C1967 The Grange, Westergate (Designer reply in red)

Engineers Comments Regarding Surface Water Drainage - Condition 10

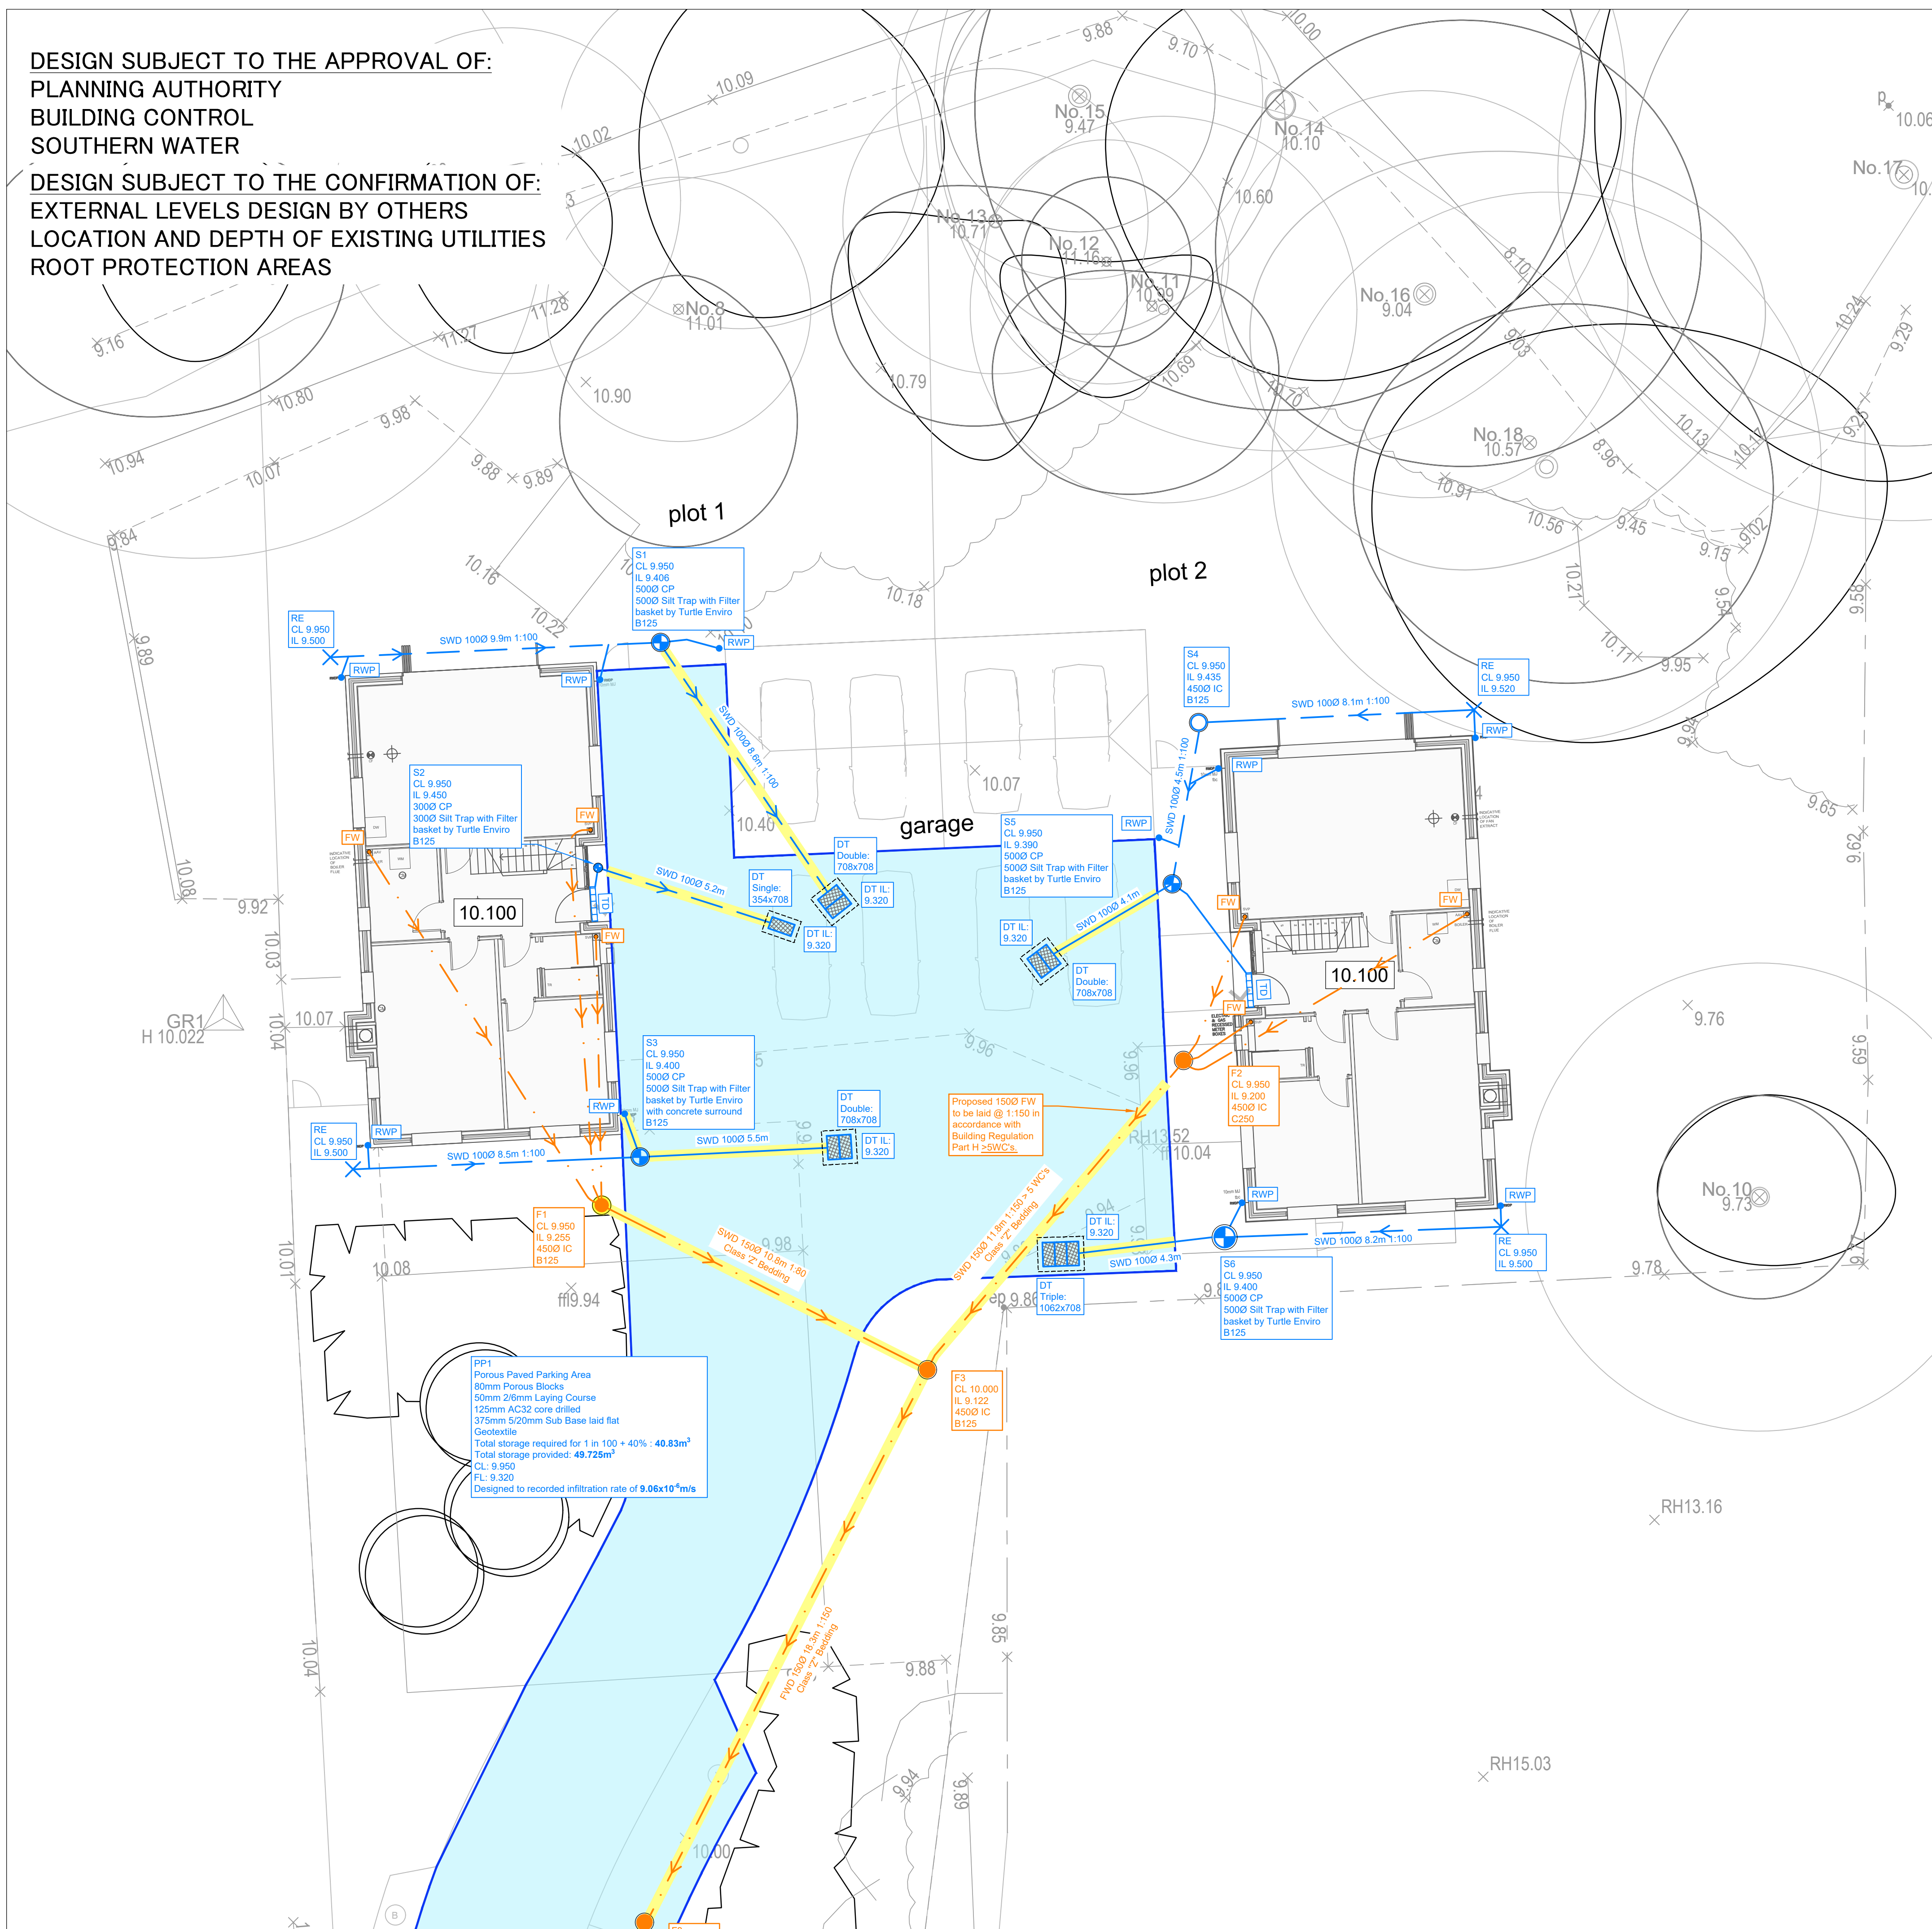
2. Please include a scale bar on the drainage layout so impermeable areas and diffuser distances from structures can be checked. Alternatively please show measurements for the same purpose.

- a. Please include pipe gradients.
- b. Diffuser blocks should be set above the 1 in 10 year +40% critical storm event. They are currently set below the formation level of the permeable paving (diffuser inverts at 9.350 – permeable paving formation at 9.370). These should also be located a minimum of 5m from all controlled structures, see point 3. Please correct.

- c. It is not clear why there are apparently random dotted lines on the drainage layout, please can their use be clarified or they be removed.

Please find updated drawing attached

The proposed diffuser block has been relocated minimum 5m away from the proposed structures. The proposed diffuser tanks act as an outlet (discharge) connection into the subbase formation. We do understand that incoming pipe IL should be set above the 1 in 10 year + 40% CC level for the traditional soakaway system, however the proposed surface water runoff will be discharged into the voided subbase and therefore to achieve this, the proposed subbase IL will need to be dropped by approx. 300mm. This will make the proposed subbase 600mm deep and due to the associated costs not viable. We could propose using a traditional soakaway system however, noting the groundwater levels surface water runoff will therefore need to be attenuated and discharged into the onsite foul drainage system. By doing this, there is a risk of the proposed SW discharge into foul drainage network being refused by statutory undertaker.

The dotted lines on the drainage layout around the diffuser tanks are indicated on drainage legend.
